DEVELOPMENT REVIEW BOARD  
February 26, 2003  
Project # 1002462

**Project # 1002462**  
03DRB-00166 Major-Vacation of Public Easements

ADVANCED ENGINEERING & CONSULTING, LLC agent(s) for SADLER SOUTHWEST LTD. request(s) the above action(s) for all or a portion of Tract(s) 3, **MENAU DEVELOPMENT AREA**, zoned M-1 light manufacturing zone, located on UNIVERSITY BLVD NE, between MENAU BLVD NE and CLAREMONT AVE NE containing approximately 3 acre(s). (H-15)

EXHIBIT B
Date 2/26/03

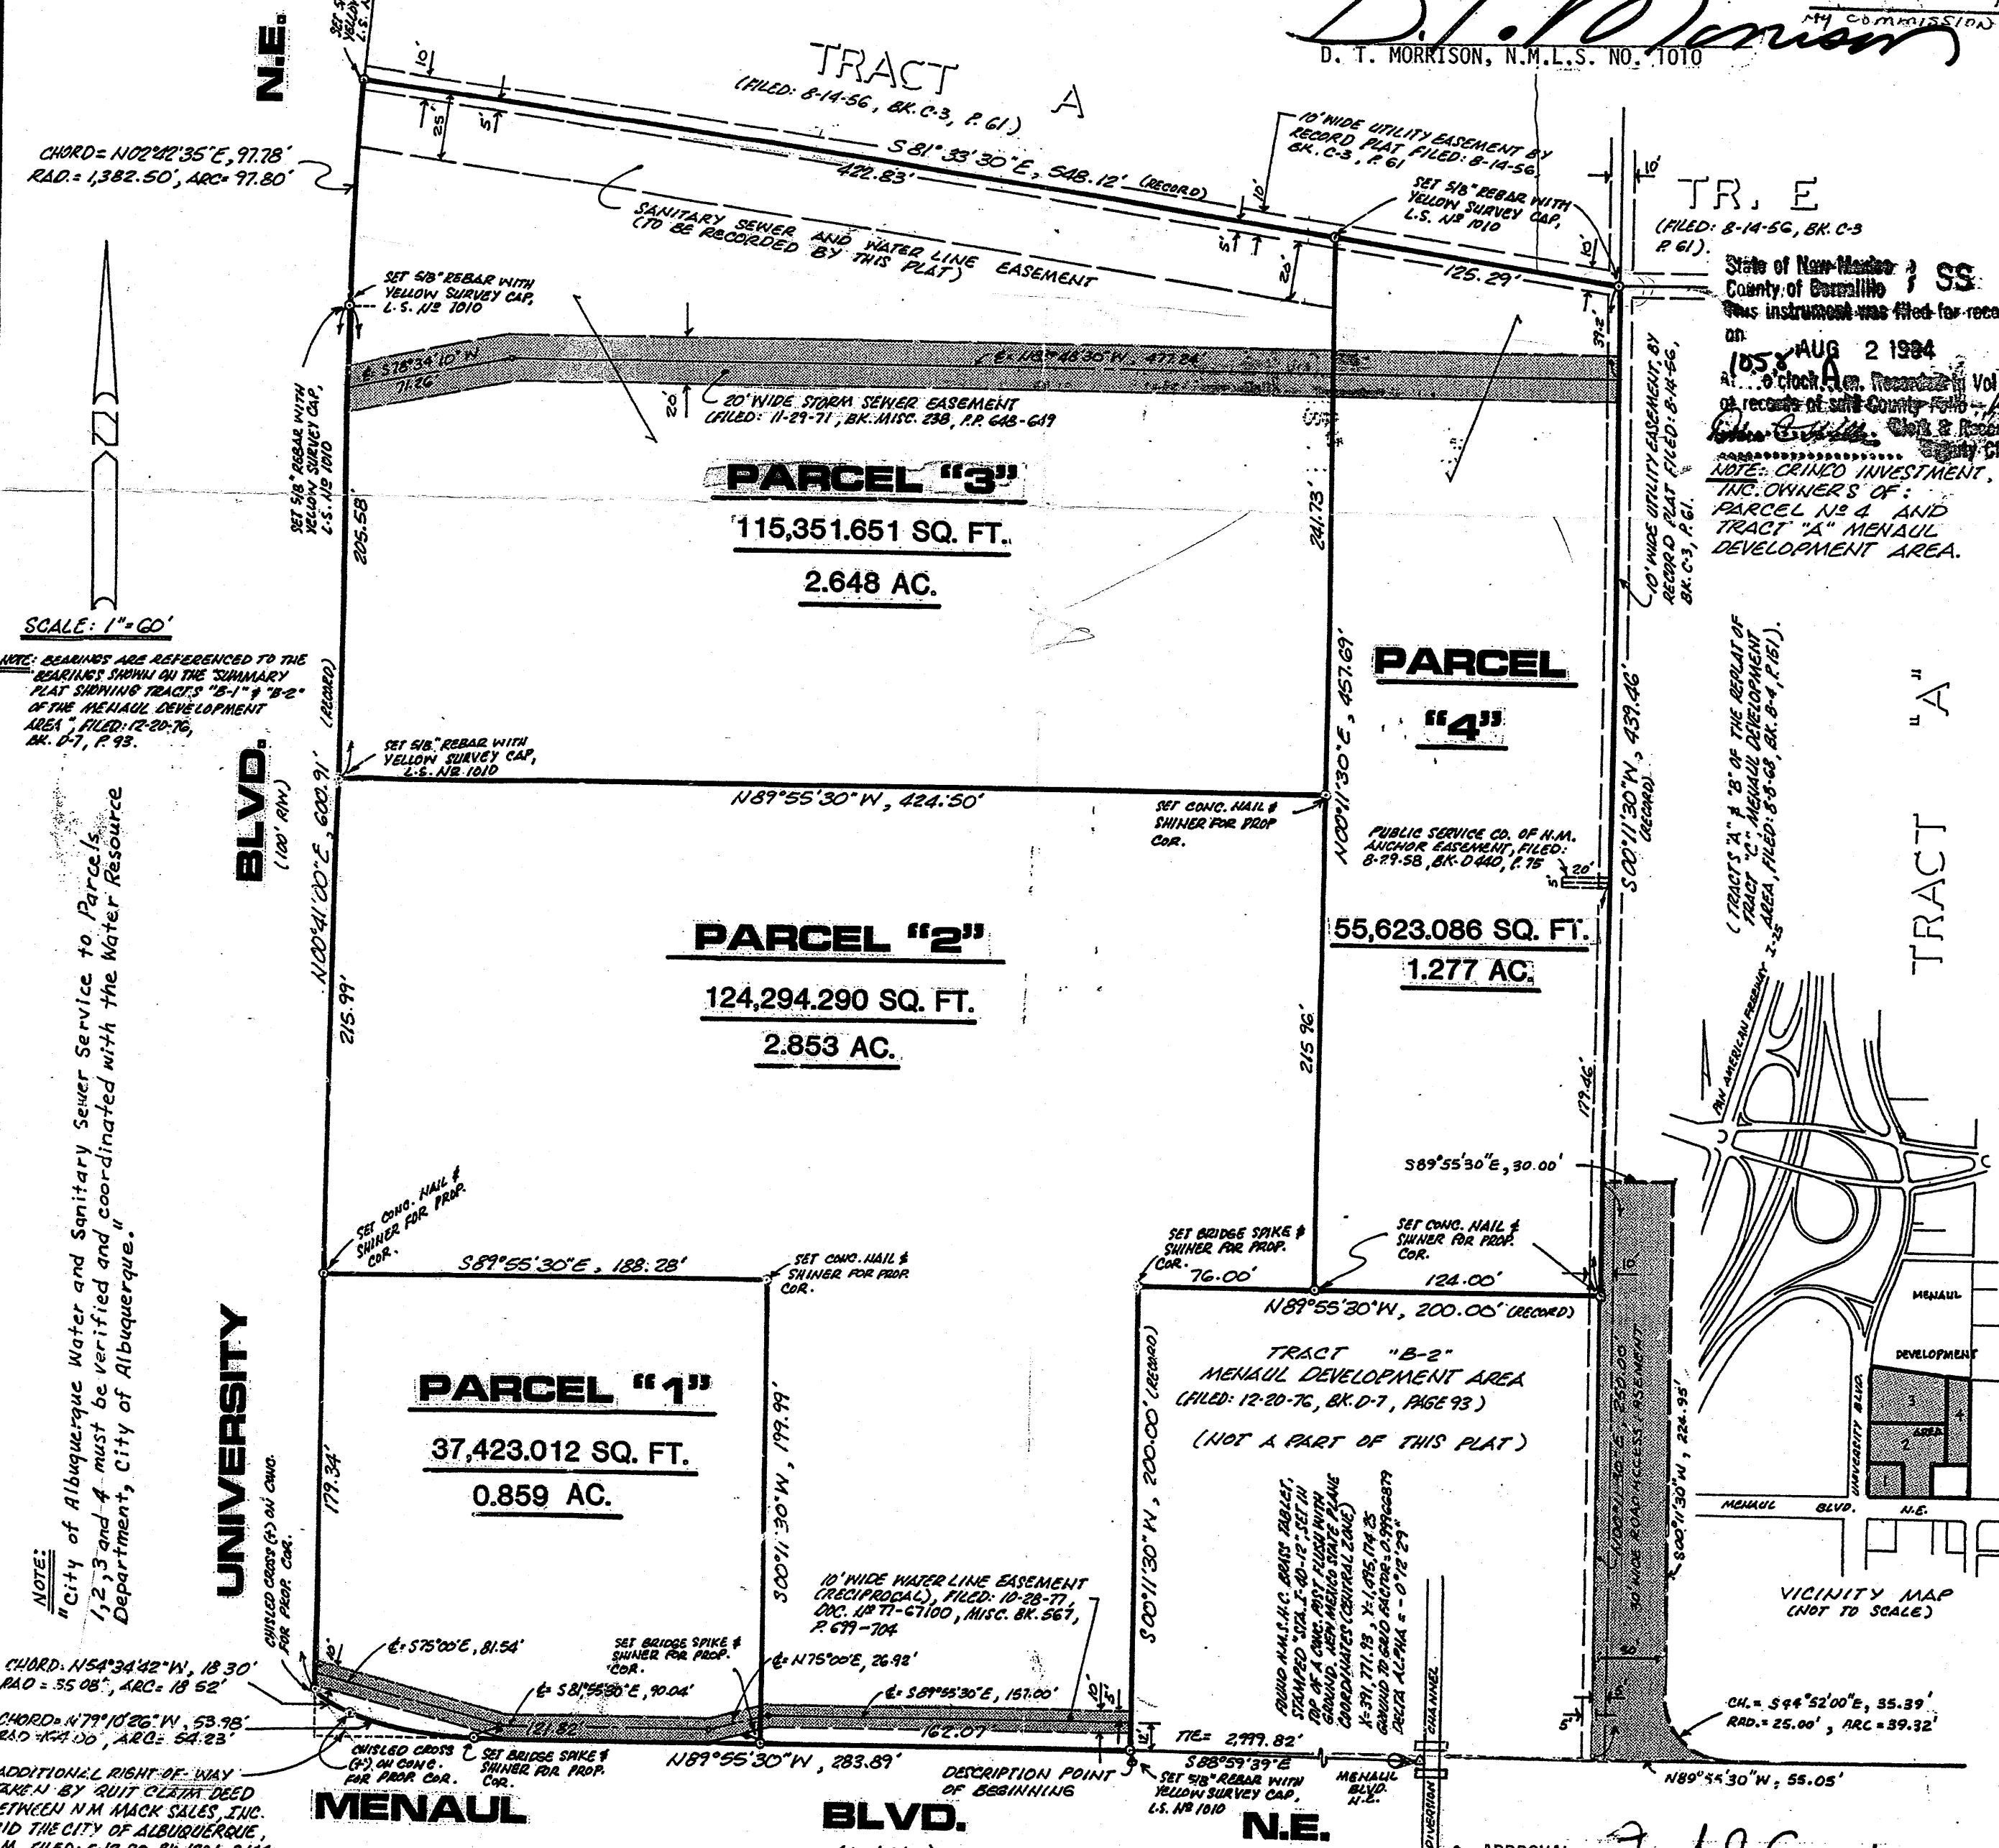
I object to Vacation of these easements. Parcel 4 to the east has rights to this easement for development of the property. I believe that the easements in question are also an Access easement.
